KITITAS COUNTY

MEMORANDUM

TO: All Staff
FROM: Justin Turnbull, County Surveyor 
DATE: December 14, 2020
SUBJECT: County Survey Review of BL-20-00006 Flying M

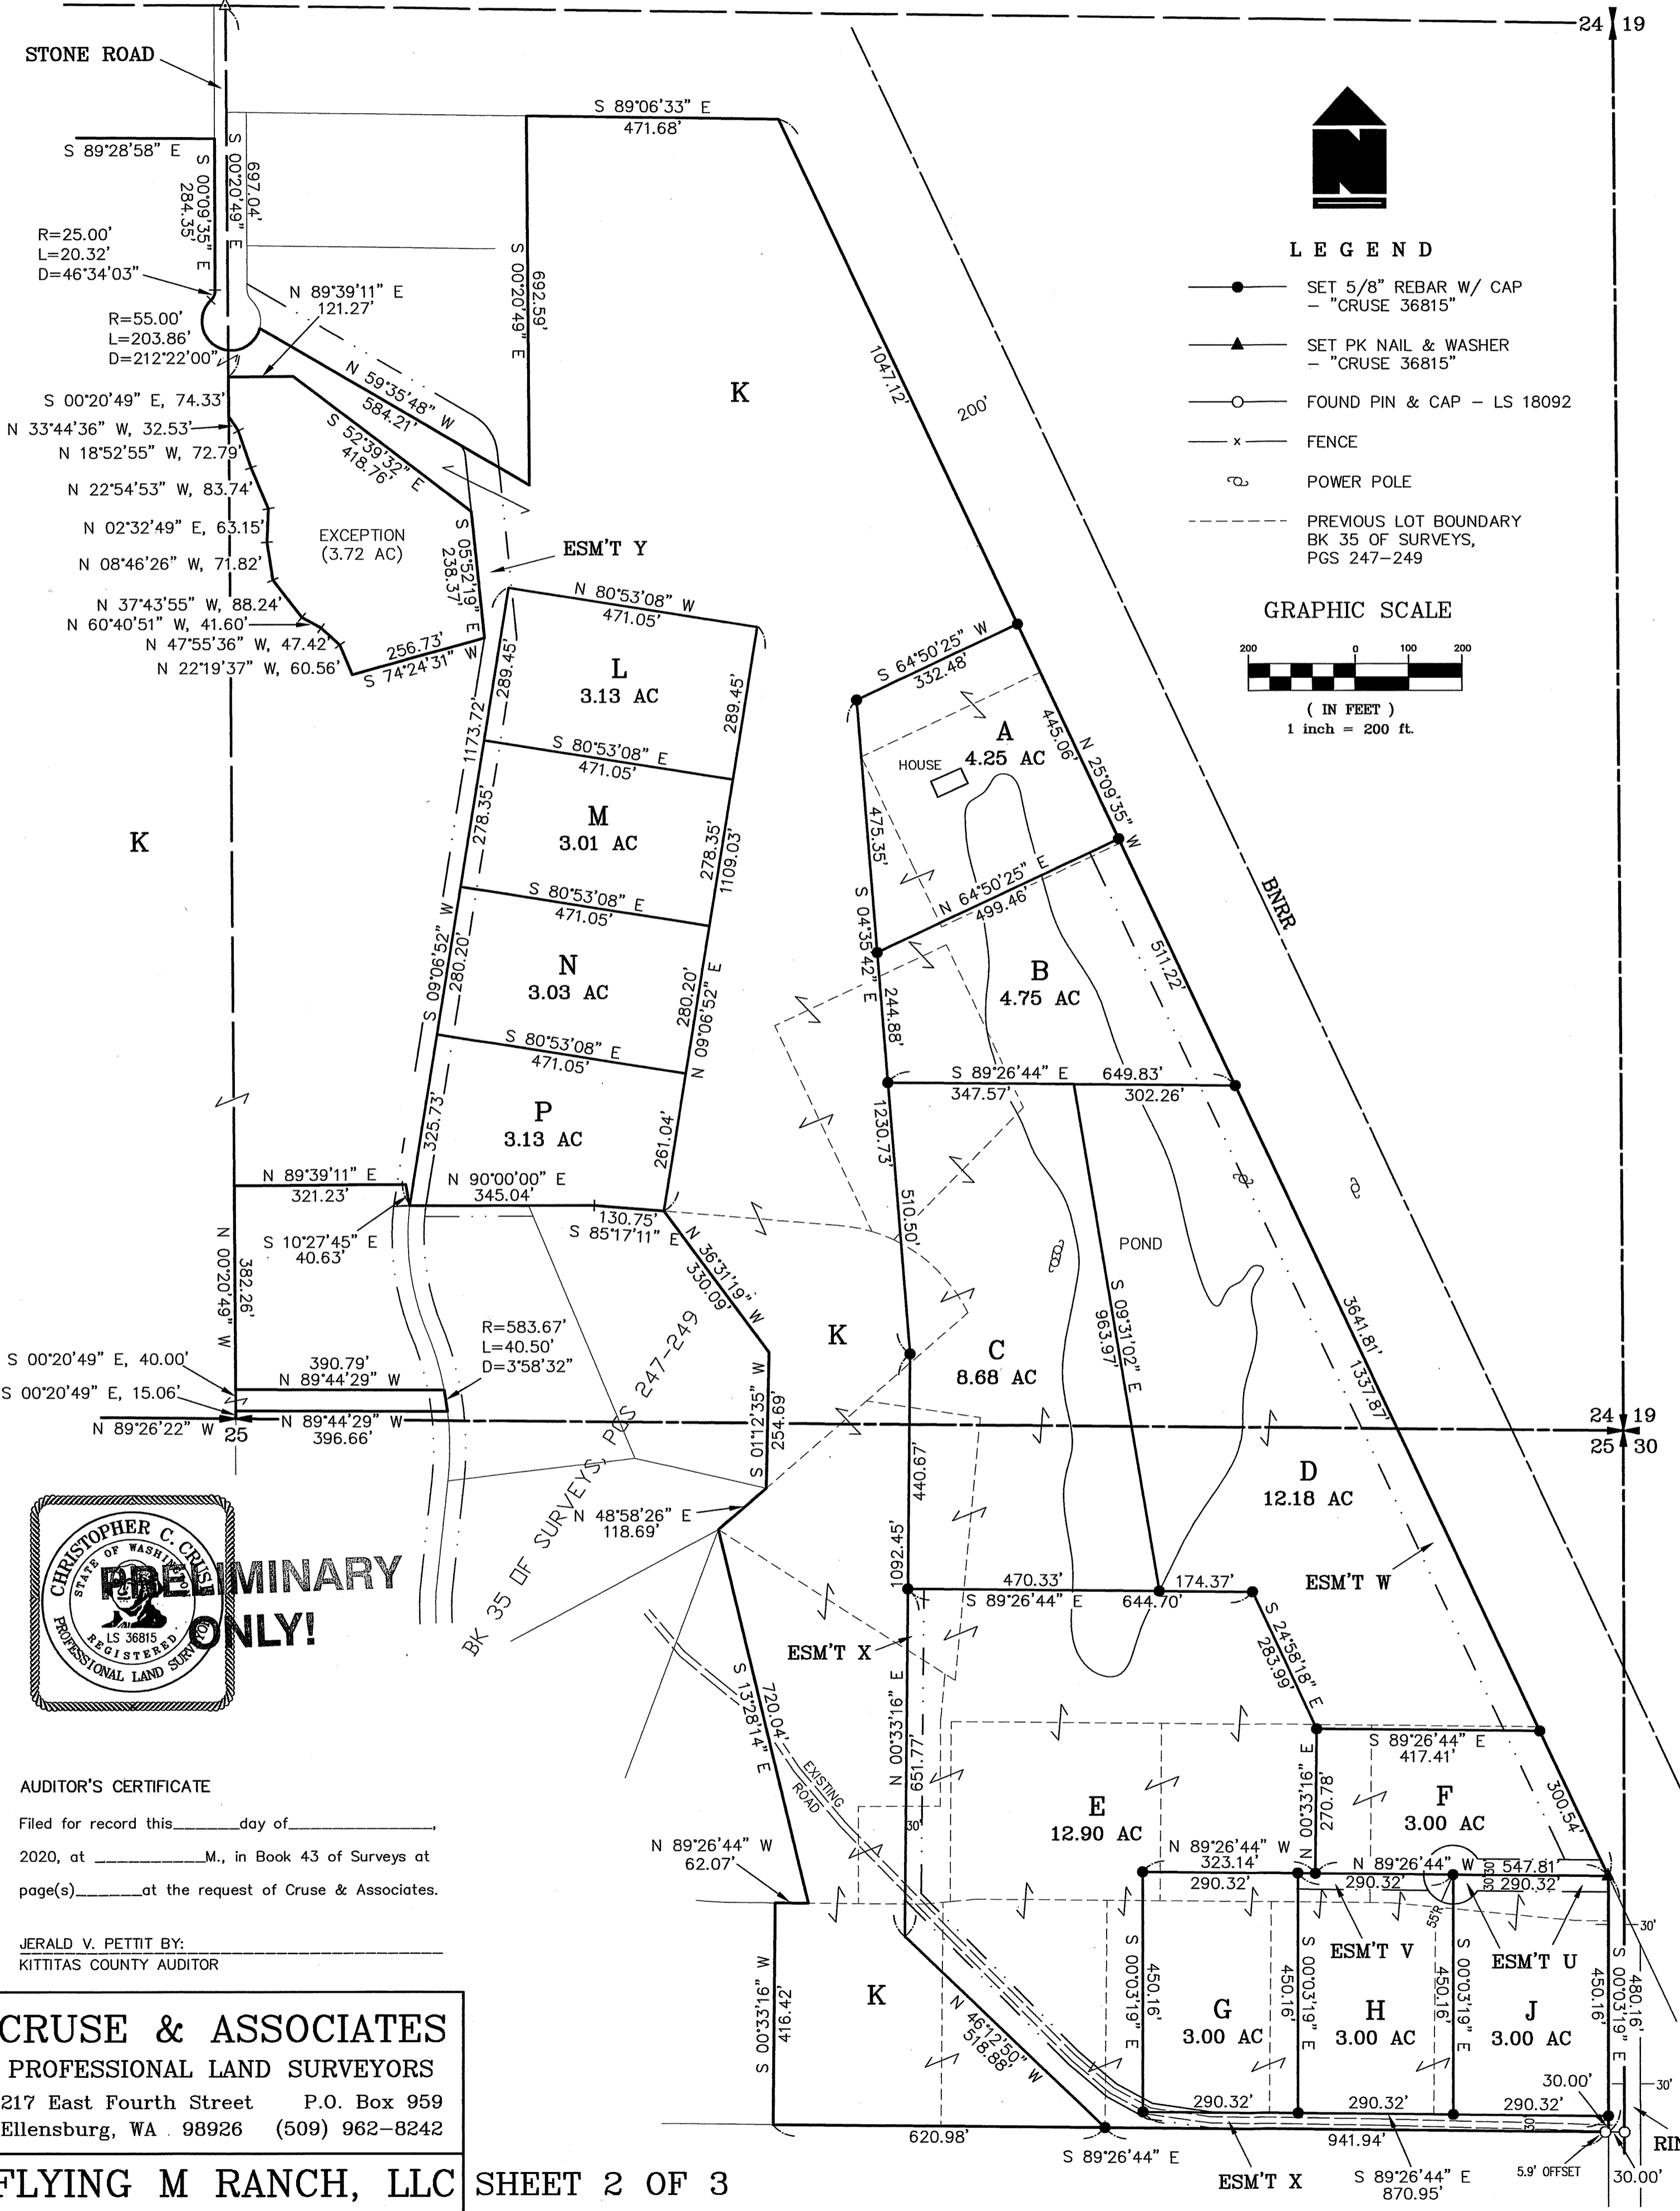
1. The boundary line of Lot K coincident with the Section line does not match that of record. The map may be revised to reflect the differences between observation and record N89°26'22"W 1291.76 (N89°26'44"W 1290.61)
2. One of the bearings on Lot 13 is missing the minute symbol (N87°06'57"E).
3. The turnaround as shown for "Easement Y" cannot be retraced from this single map. Applicant may want to include ties to be able to recreate this position from this survey (alternatively, the proposed easement description could be revised to refer to Book 35 of Surveys, page 247 rather than this survey).
4. The pond located on lots C, D and K should be shown.
5. Minor closure corrections already discussed with applicant.
